KITTITAS COUNTY

MEMORANDUM

TO: All Staff
FROM: Justin Turnbull, County Surveyor 
DATE: May 10, 2021
SUBJECT: County Survey Review of BL-21-00006 Mundy

PART OF SECTIONS 27, 28, 33 & 34,
TOWNSHIP 20 NORTH, RANGE 16 EAST, W.M.

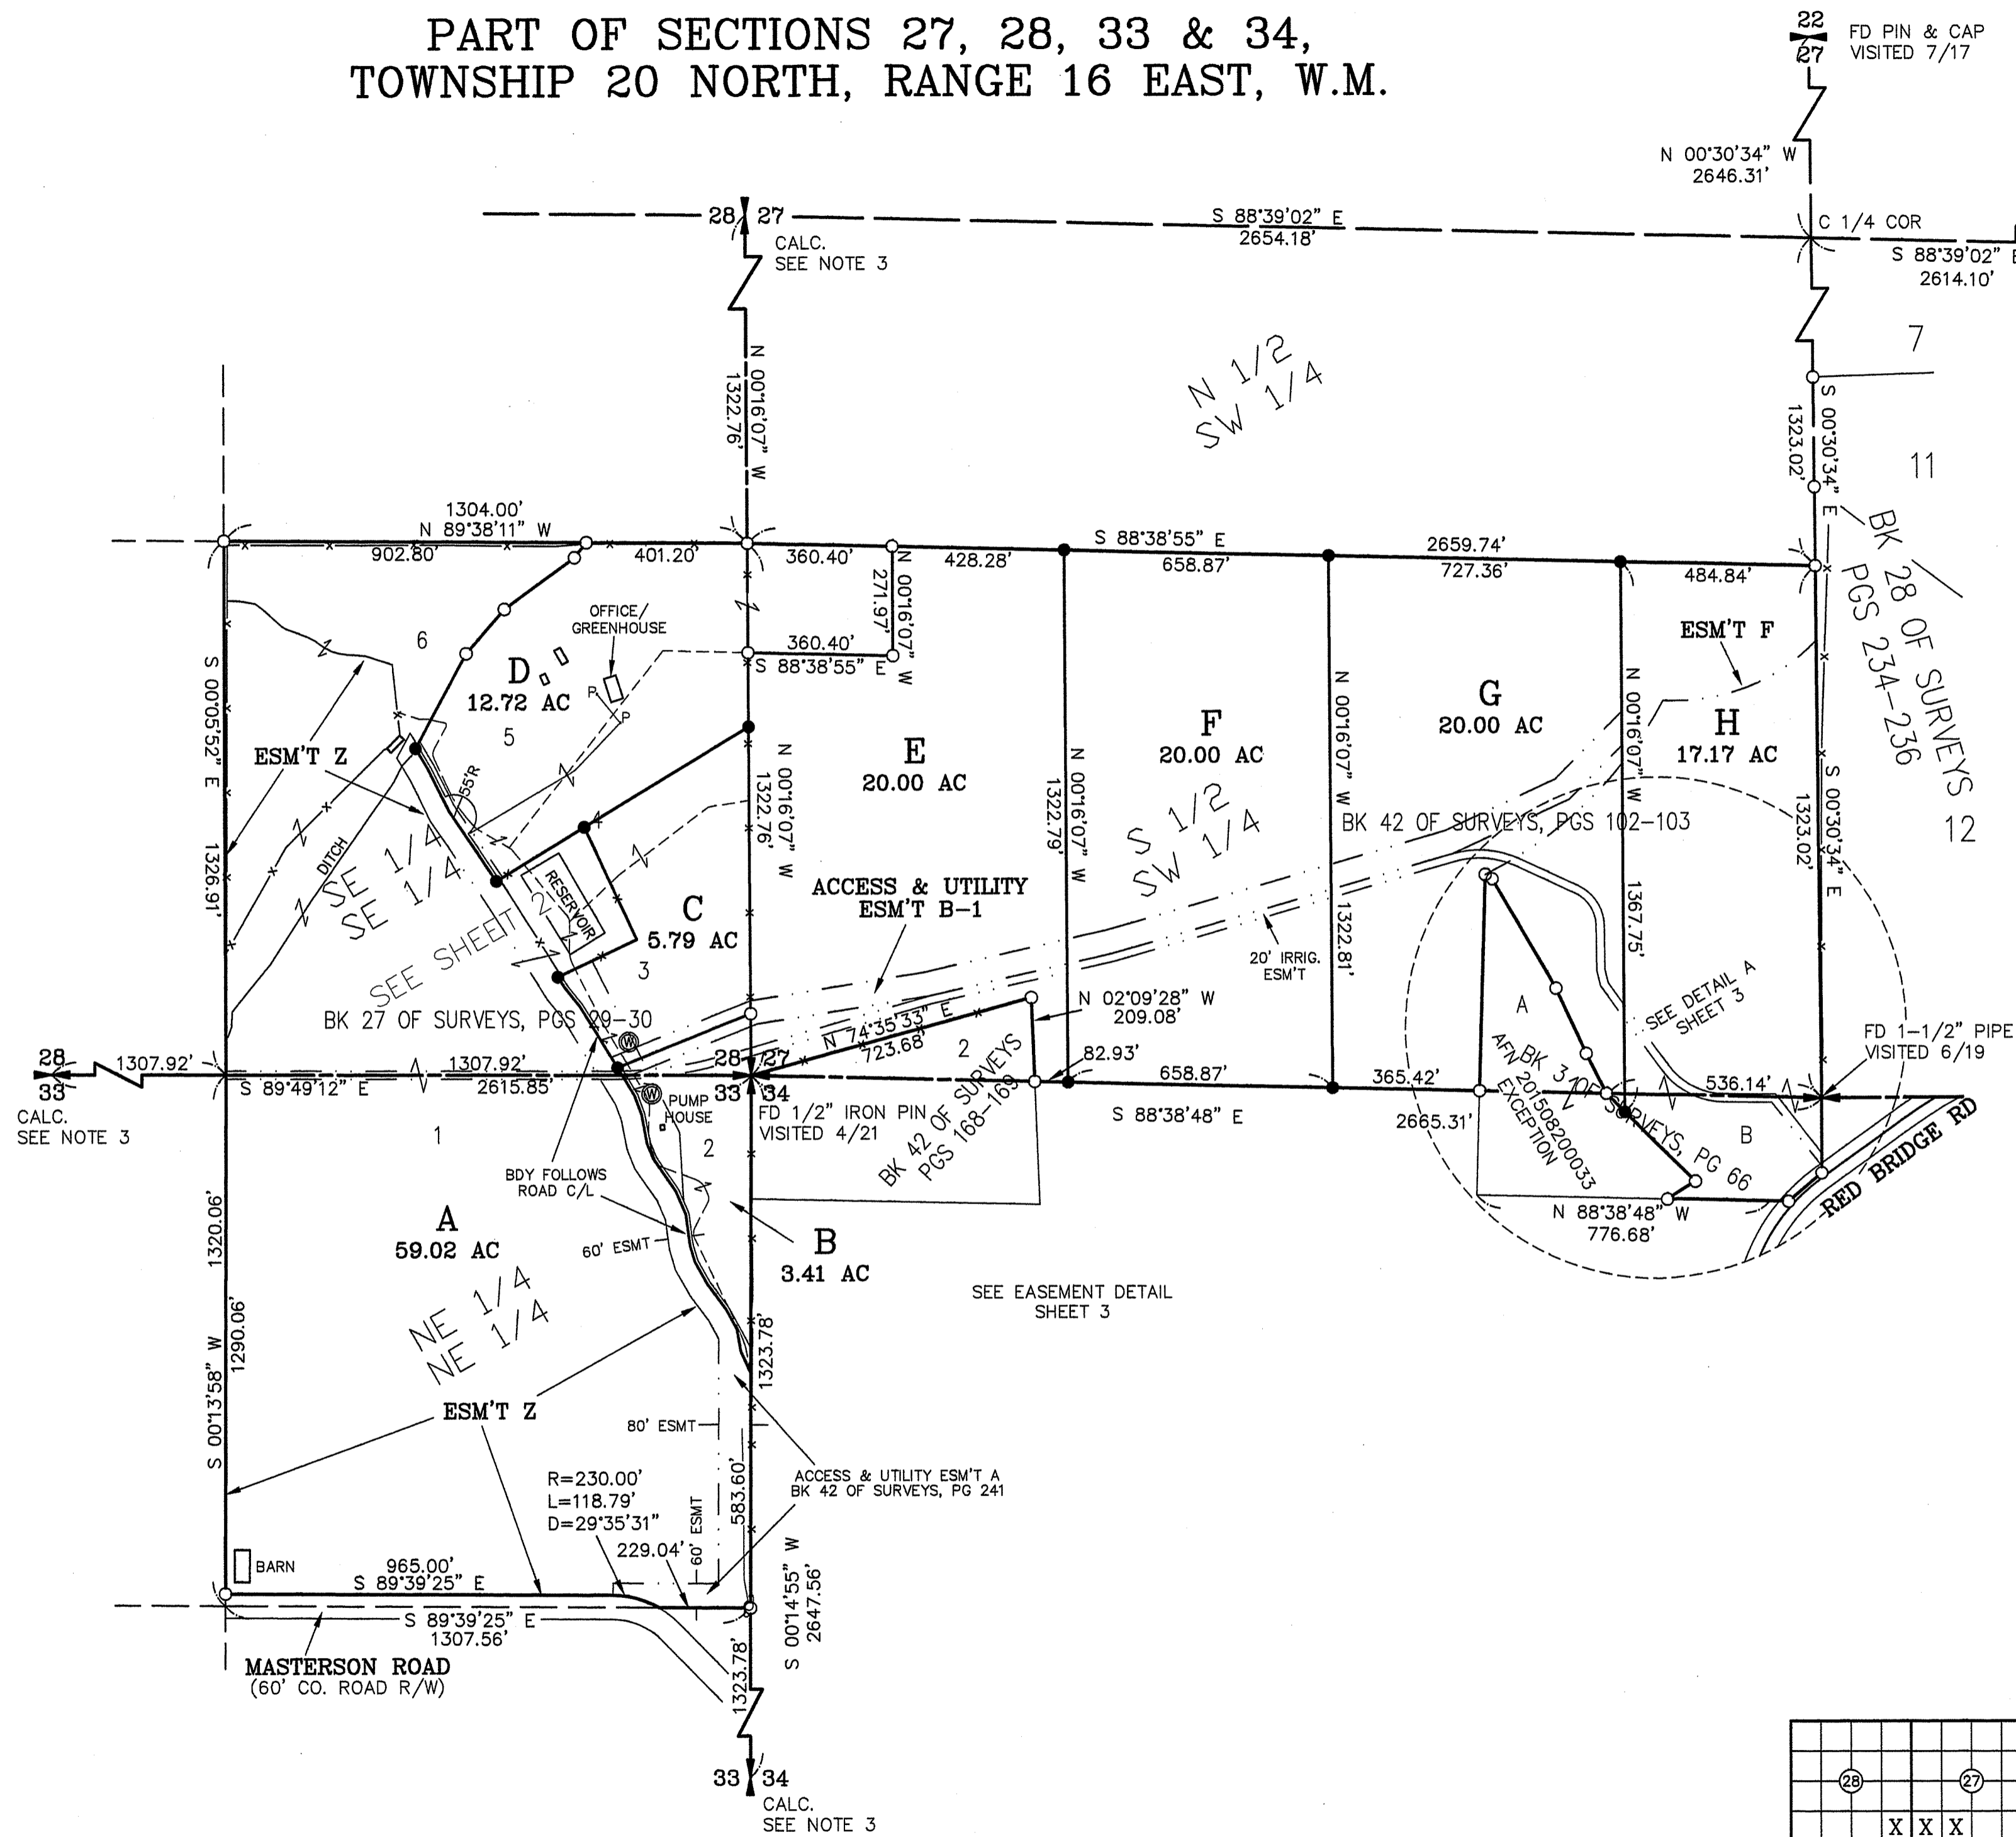
1. There are multiple occurrences of text being obscured by crossing linework on sheets 1 and 2.
2. Sheet 4 contains a vertical line through the legal descriptions of Parcels E through G.
